Your ref:	Moyagi, London	<b>Please reply to:</b>	<b>Mr Gregor Gault</b>
Our ref:	23/08553/ADV	Tel No:	
		Fee Queries:	0207 641 6500;
		Email:	planningreception@westminster.gov.uk;
Mr Scott Little Projects Group 10 Quarry Court Quarry Road Pitstone LU7 9GW		<b>Incomplete Applications</b> Town Planning & Building Control City of Westminster PO Box 732 Redhill, RH1 9FL	
		19 December 2023

**Address: 5 Cavendish Place, London, W1G 0QA,**

**Proposal: Display of an internally illuminated projecting sign measuring 20cm x 100cm.**

Projecting sign 1000x200mm
135cdm2
Scale 1:5

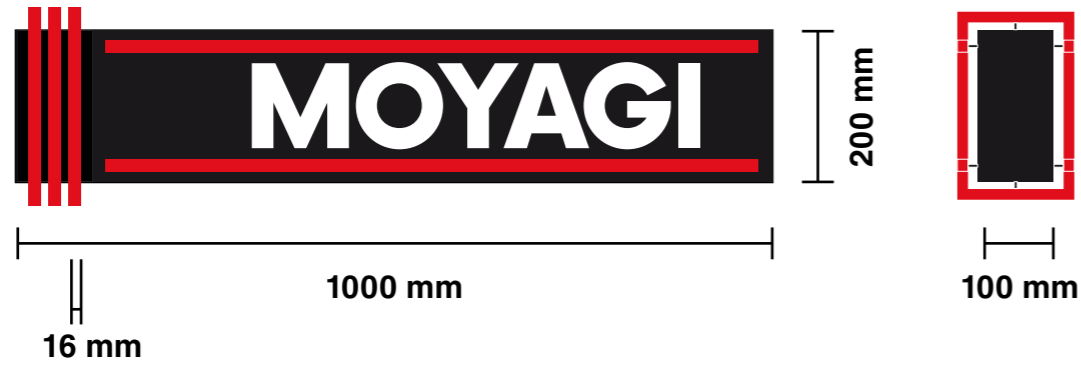
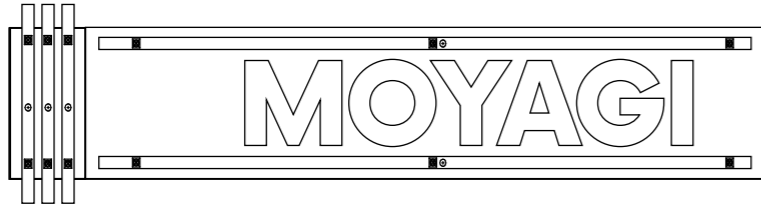
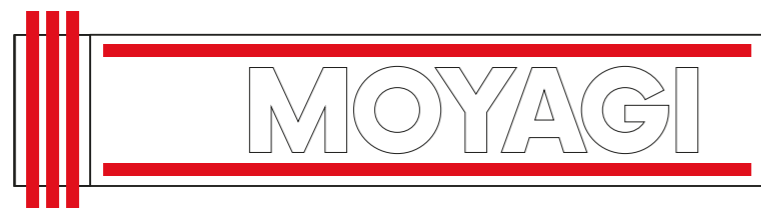
- 1 Please provide metrically scaled existing elevation drawings that include a scale bar.
  - 2 Please provide metrically scaled existing and proposed section drawings. These must include a scale bar.
  - 3 Please provide a more detailed section drawing of the proposed sign that more clearly shows the method of illumination including the luminance values.
- 0 \*Please collate all requested information in a single submission and send to [planningreception@westminster.gov.uk](mailto:planningreception@westminster.gov.uk). Sending your documents individually will not speed up the process. Please do not upload to the planning portal as this causes duplication and may delay the processing of your application. Thank you.\*
